Addendum No. 1

RE: Contract ID C203916
WBS # 44797.3.1
F. A. # NHP-0485(044)
Mecklenburg County (I-5960)
I-485 From MM 35.8 To MM 39.7

November 15, 2016 Letting

STATE	PROJECT NO.	SHEET NO.	TOTAL SHEETS
N.C.		1	
WBS NO. 44797.3.1

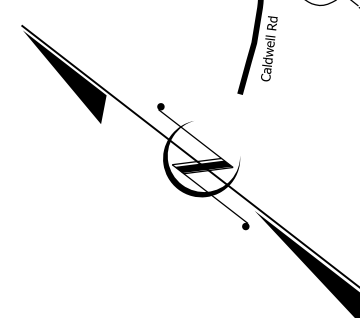
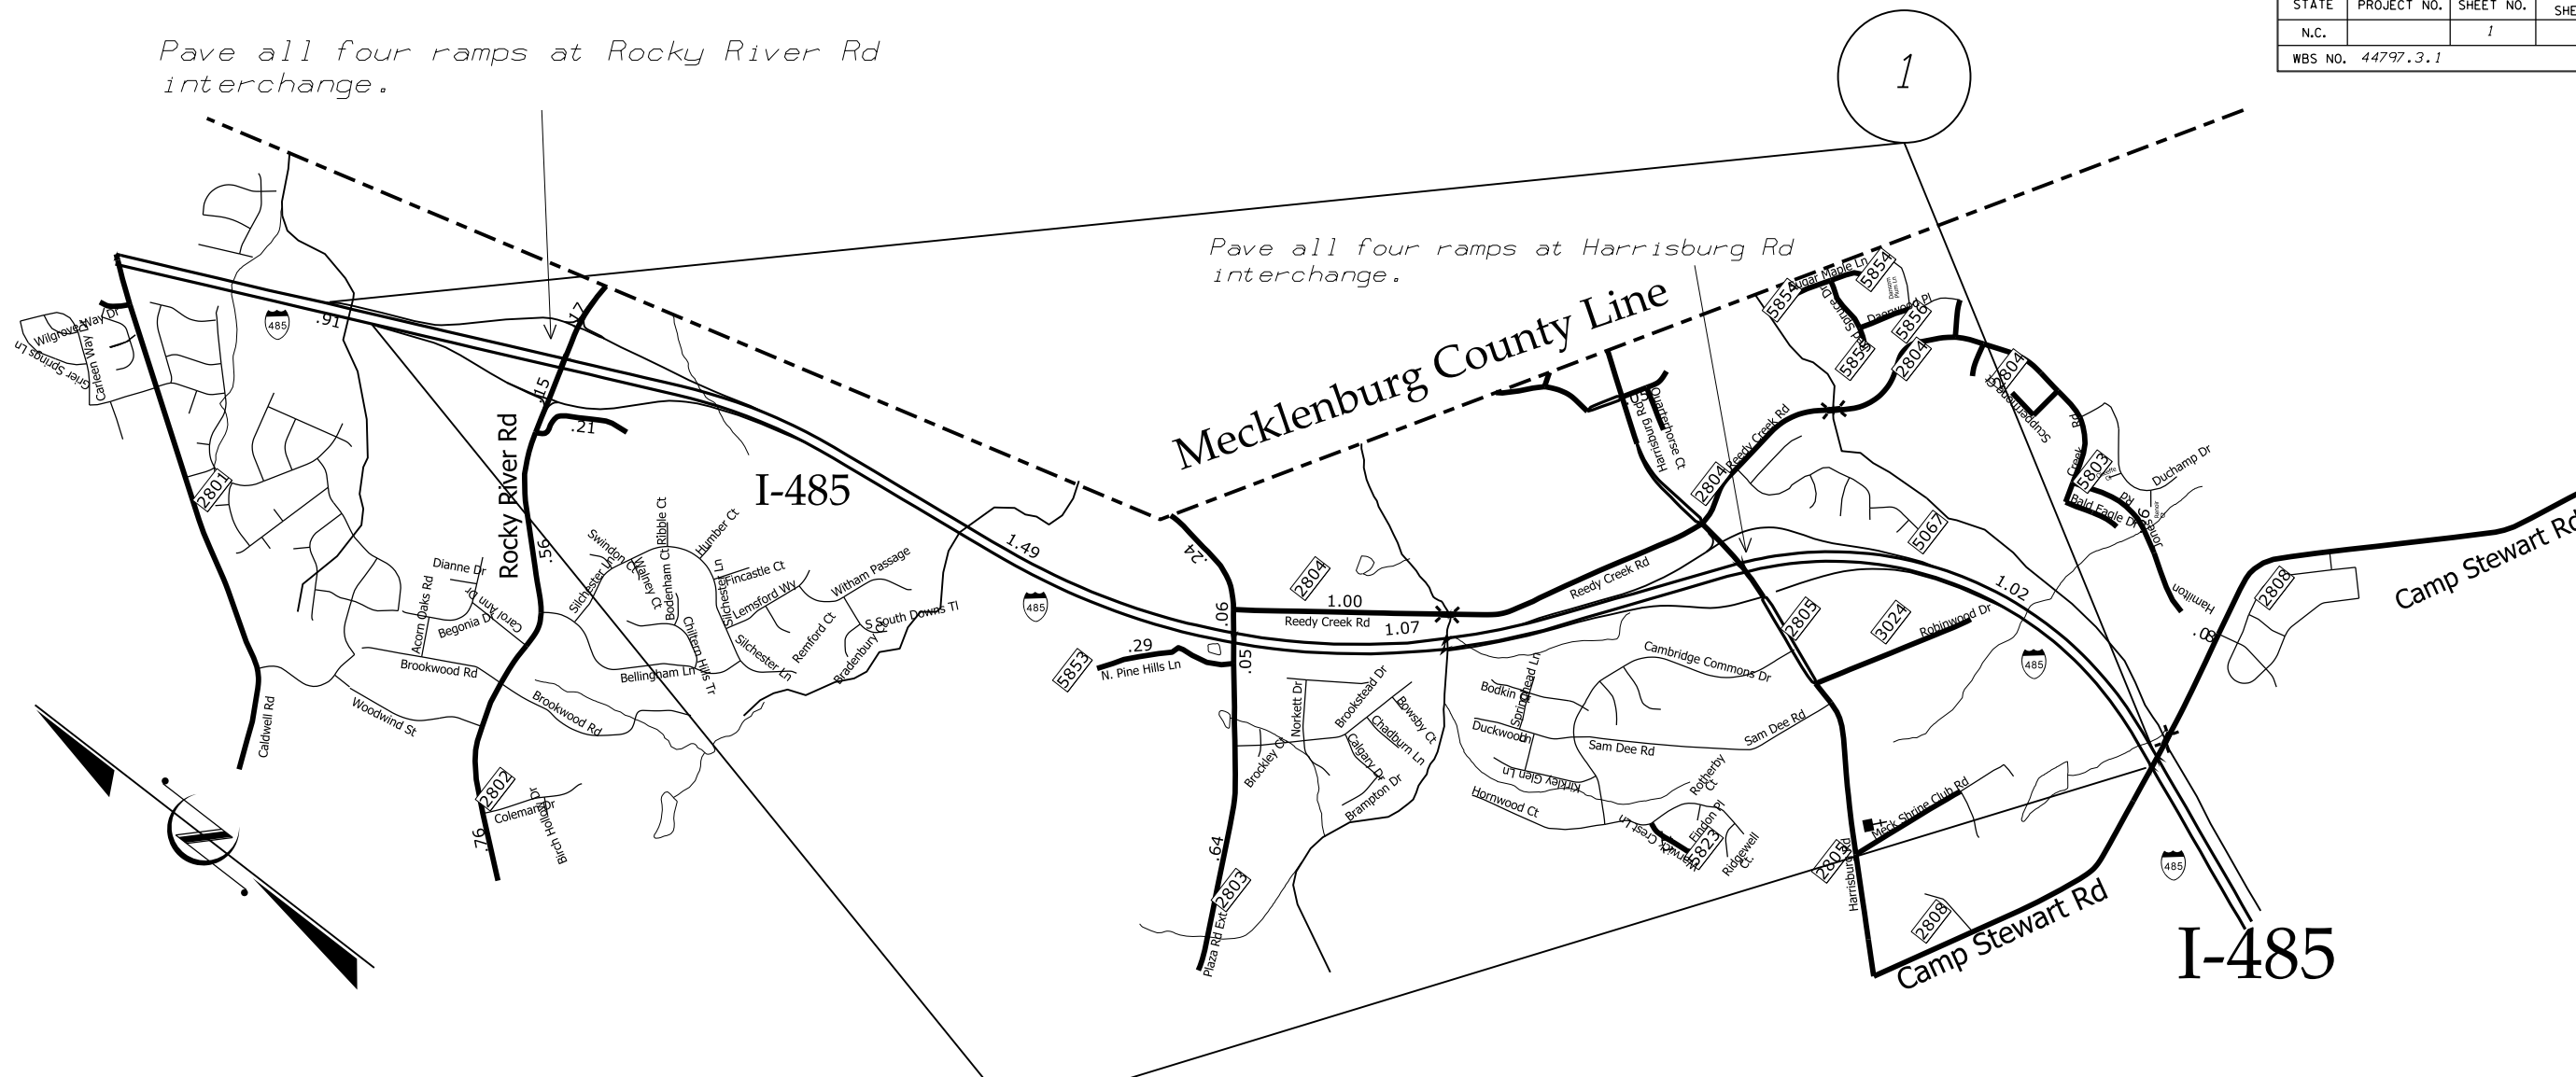
Sheet No.	Revisions
1	Removed note #5 from the list of notes
4	Revised Typical #6 to show the existing island at a lower elevation
5	Revised to remove the details for "Speed Measurement Markings". The sheet is now "Intentionally Blank"
7	Revised the Summary of Quantities to correct the quantity of 6" Cold Applied Plastic Pavement Marking Lines
